19 November 2013

TNT WAREHOUSE AND DISTRIBUTION CENTRE (SSD 6040)

RESPONSE TO SUBMISSIONS

A NORTH ELEVATION
200 Scale 1:1000

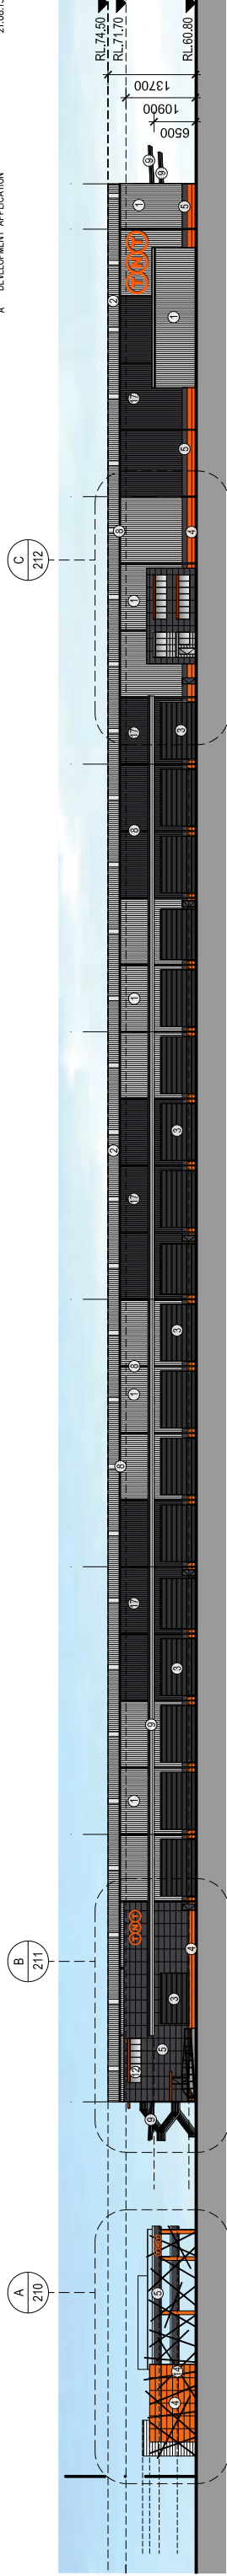
Penrith City Council	
<p>Architectural merit of the proposed building Consideration should be given to the design elements of the northern elevation of the building including:</p> <ul style="list-style-type: none">• Breaking up the roof form;• Greater use of articulation and colour; and• Utilising exposed frames and oversized elements such as downpipes to create visual interest.	<p>The northern elevation of the building has been improved by adding:</p> <ul style="list-style-type: none">• Precast panels extending to the eaves line to breakup the roof form and geometry;• Additional colour to intersperse the corporate colour and help punctuate the wall panels; and• Oversized downpipes painted in contrasting colours to provide more contrast and visual interest. <p>Attachment 1(a) is revised drawing DA-002(B); Attachment 1(b) revised drawing DA 200(B); and Attachment 1(c) is a new drawing to the original DA set. This drawing DA 201(A) was added as the scale of the overall elevation was a little difficult to read at A3 size.</p>
